**Consultation Response from: KC Environmental Health (Pollution & Noise Control)**
**2023/91949 - Peace Wood Quarry, Huddersfield Road, Shelley, Huddersfield, HD8 8LH**
**Extension to existing quarry**
**Date Responded:**  
**4<sup>th</sup> September 2023**
**Responding Officers:**  
**RM, MN & NH**
**Responding Ref:**  
**WK202325693**

# Drawing Title: Extraction Plan

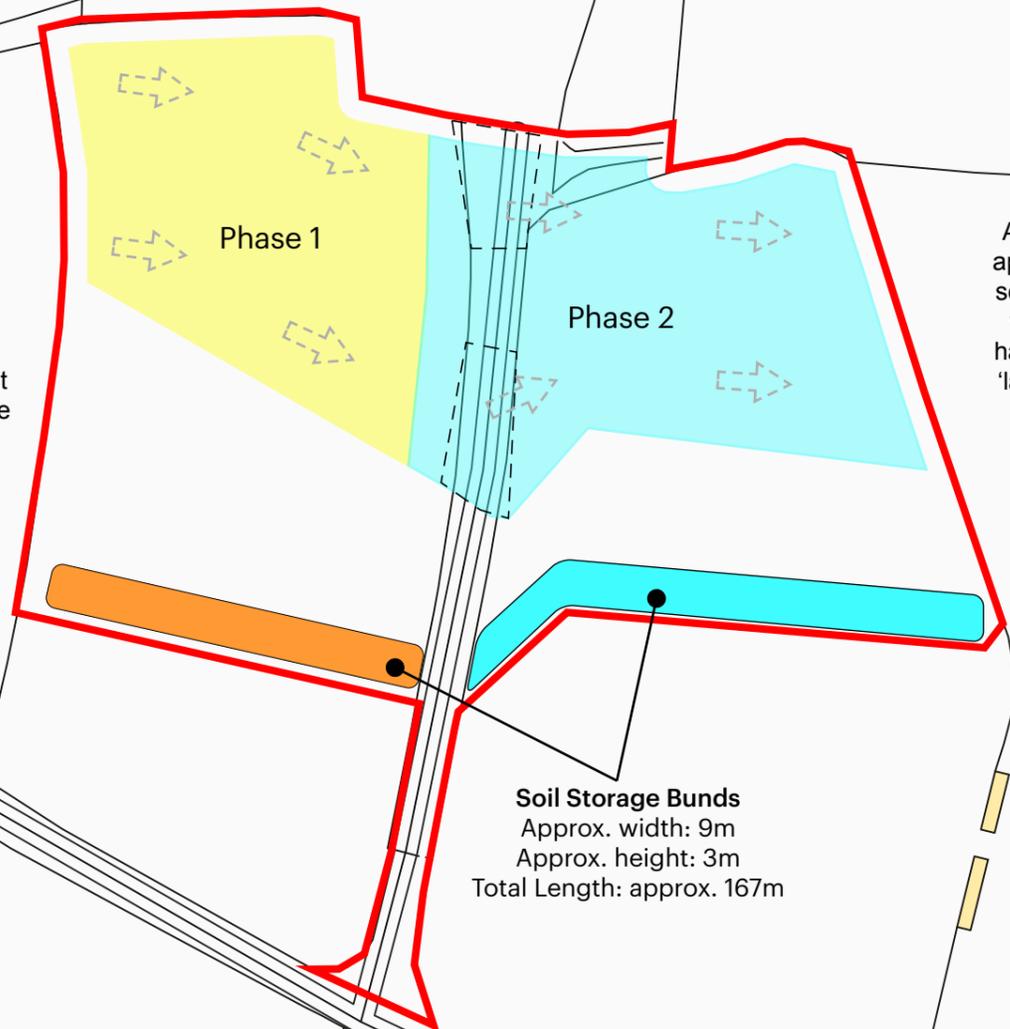
In mitigation, a bund is recommended as shown in the submitted plan from MPG dated 16 February 2023 Ref 320/1 – Ext3 Rev5 as follows –

- Approx. width: 9m
- Approx. height: 3m
- Approx length: 167m

A condition is recommended for the erection of the bund to ensure compliance with the mitigation recommendation.

Before any mineral extraction commences, all mitigation measures which form part of the sound attenuation scheme as specified in the Noise Impact Assessment authored by Nova Acoustics dated 25 July 2022 Ref 8073MP shall be completed. Written evidence shall be submitted to and approved in writing by the Mineral Planning Authority verifying the installation as per the submitted plan from MPG dated 16 February 2023 Ref 320/1 – Ext3 Rev5 .

Figure 2.0 – Specific Sound Level Map – 1.5m Grid Height

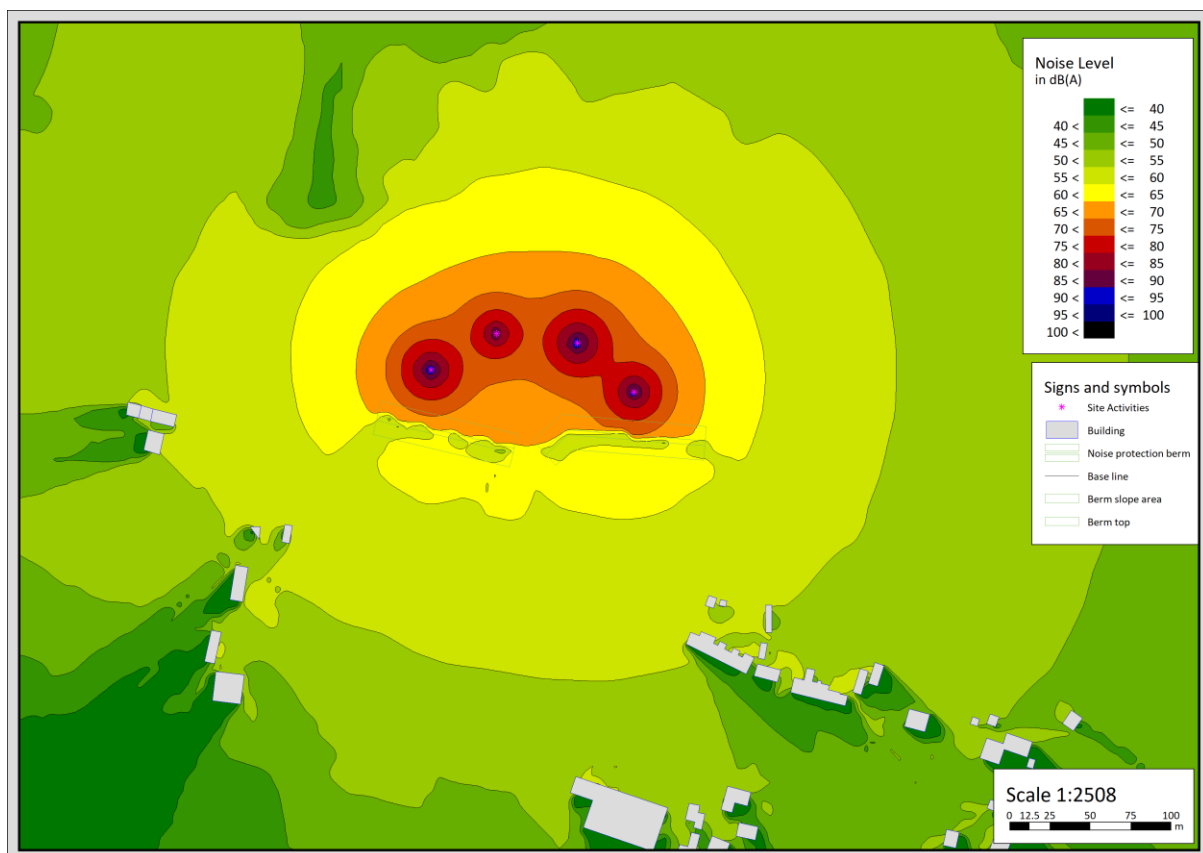
A BS4142 assessment has been conducted based upon the main noise generating equipment including the HGV movements and noise modelling shown in figure 2. The assessment has applied penalties for tonality (+2dB), impulsivity (+3dB) and intermittency (+3dB) and the results in table 7 show exceedances at all NSRs as follows –

- NSR1 - +8dB
- NSR2 - +7dB
- NSR3 - +7dB

Reference is made to Planning Practice Guidance - Mineral Extraction which states '*Mineral planning authorities should aim to establish a noise limit, through a planning condition, at the noise-sensitive property that does not exceed the background noise level ( $L_{A90,1h}$ ) by more than 10dB(A) during normal working hours (0700hrs to 1900hrs)*'. A condition is recommended to ensure compliance with the guidance.
